PORTLAND MAINE

May 22, 2009

RE: 38 Savoy Street – 428-L-011 – R-5 Zone

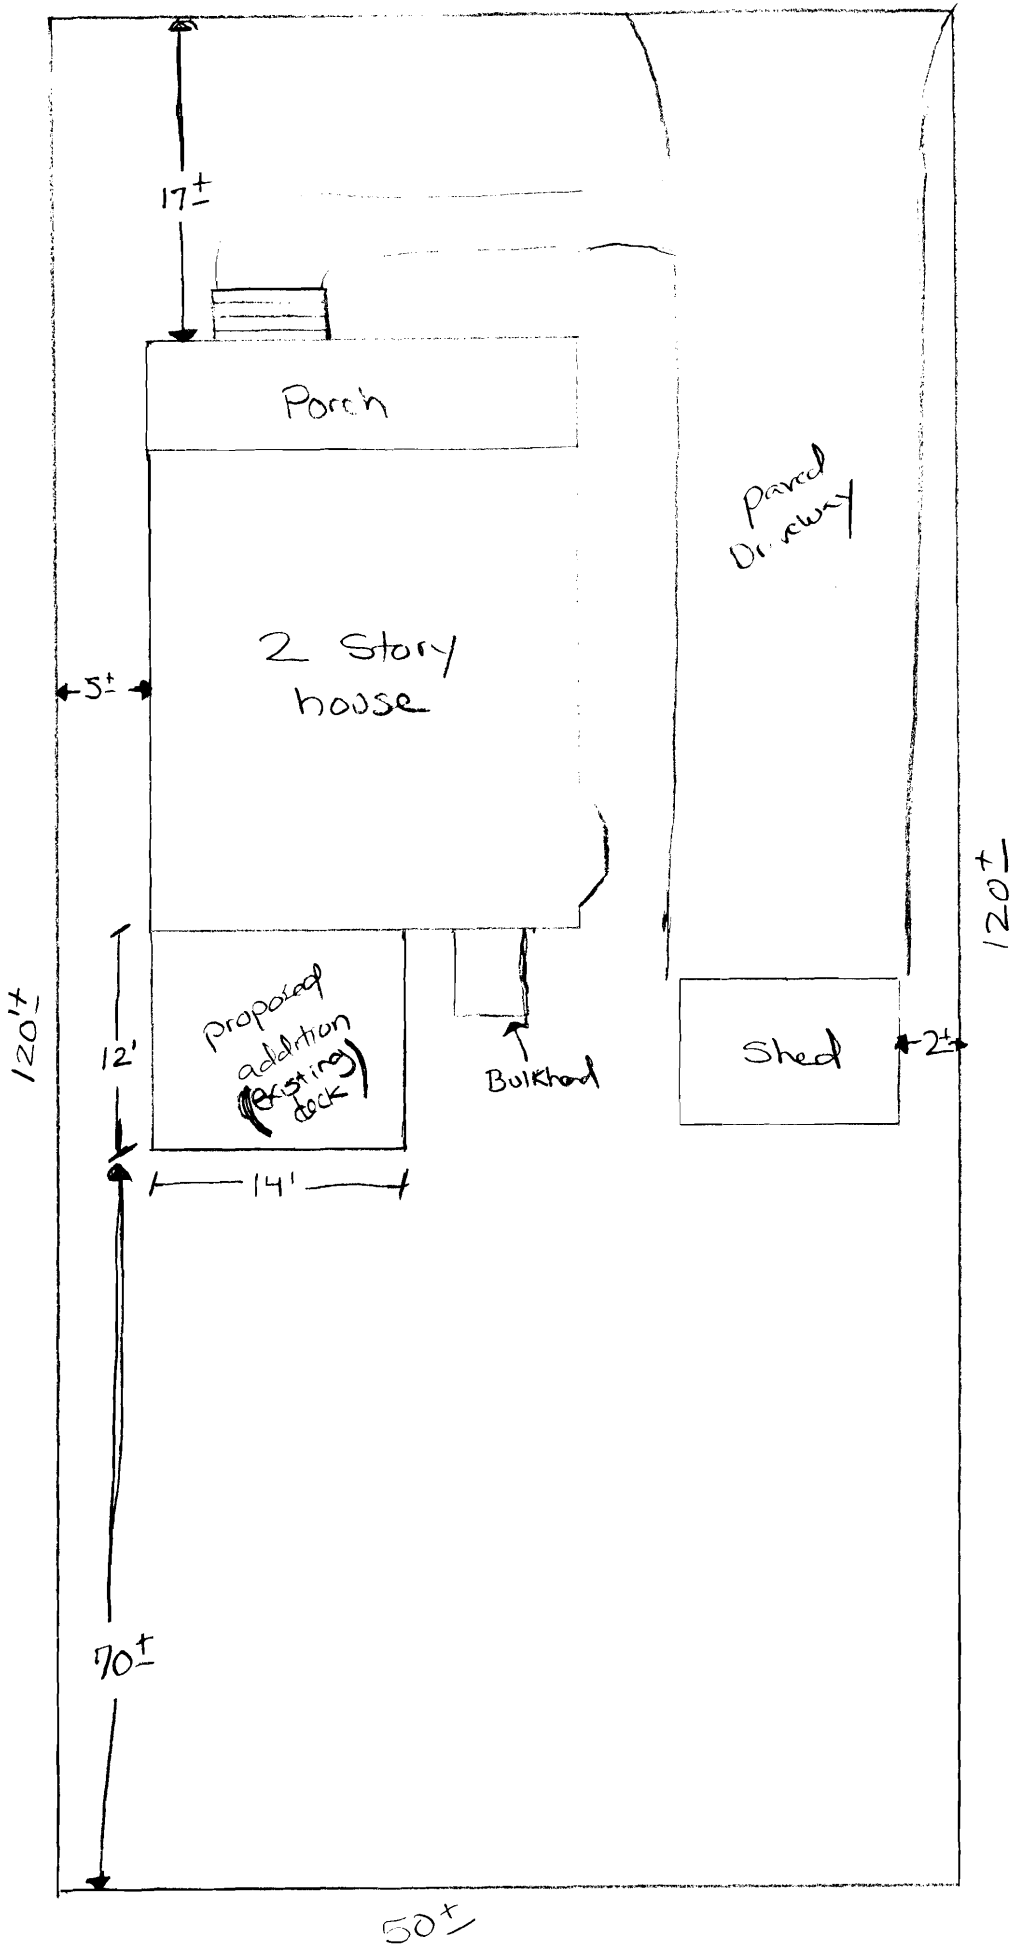
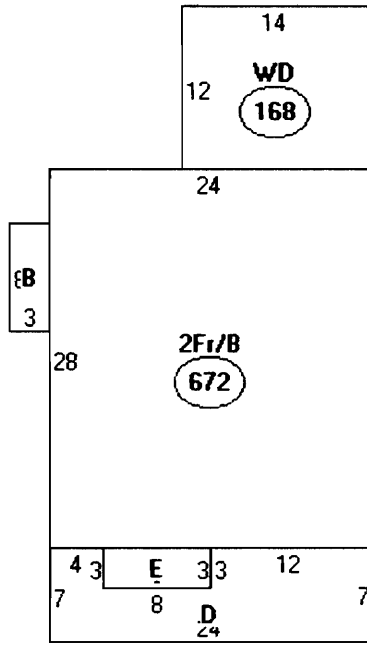
Recently this office issued you a permit to remove an existing rear deck and replace it with a 3 season room. During the permit review of the plot plan that you submitted, it came to my attention that there is a shed that is improperly sited on your property. Our records show that a required permit for the 10'3" x 12'3" shed was never applied for and never approved by this office. Your submitted plot plan shows the shed to be setback 2' from the side property line instead of the required minimum side setback of 5' for a detached structure 144 square feet or less in size (section 14-120(d)3).

It will be necessary to correct this violation. Please note that such zoning violation(s) will affect any future property sale. We will be glad to work with you to bring your shed into compliance with the required permits and approvals. Please give me a call at 874-8695 so that we can meet and go over your options concerning this shed.
